Our Ref: BR/299/17/A
Your Ref:

Town & Country Planning (Control of Advertisement) (England) Regulations 2007 (as amended)
Application for Consent to Display an Advertisement(s)

Development 1 No. non-illuminated hoarding sign

Location Unit 1 Christie Place Bognor Regis

SITE LOCATION PLAN
AREA 4 HA
SCALE 1:1250 on A4
CENTRE COORDINATES: 493718, 100468

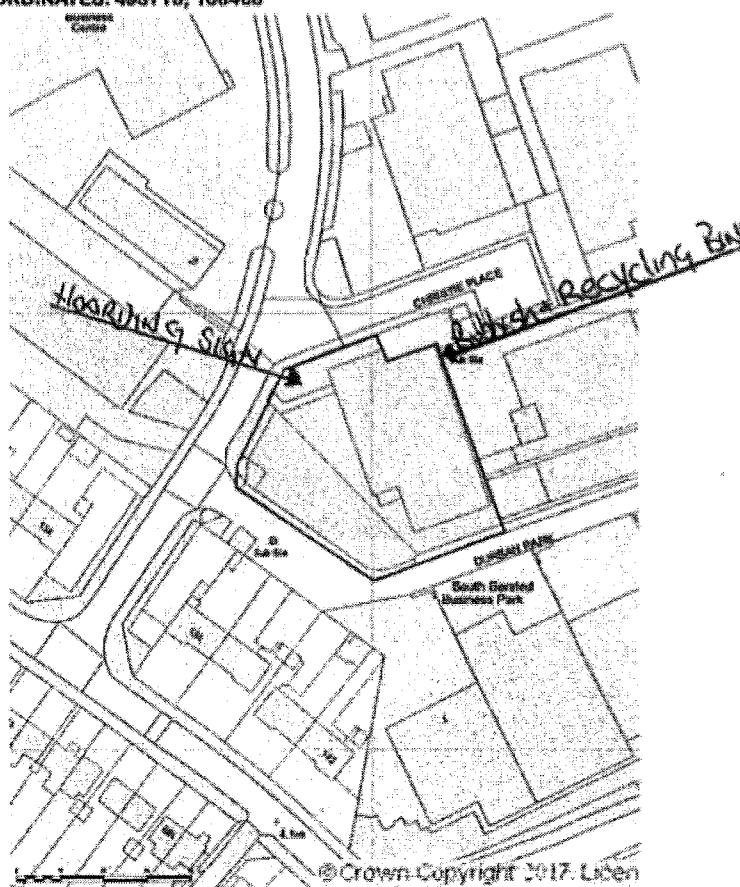
Location Plan Amend

Please submit 1 electronic or 3 paper copies of a location plan at a scale of 1:1250 or 1:2500 for rural areas. Further details of what must be included on the plan can be found in the National Validation Requirements. Please highlight the position of the proposed hoarding sign.
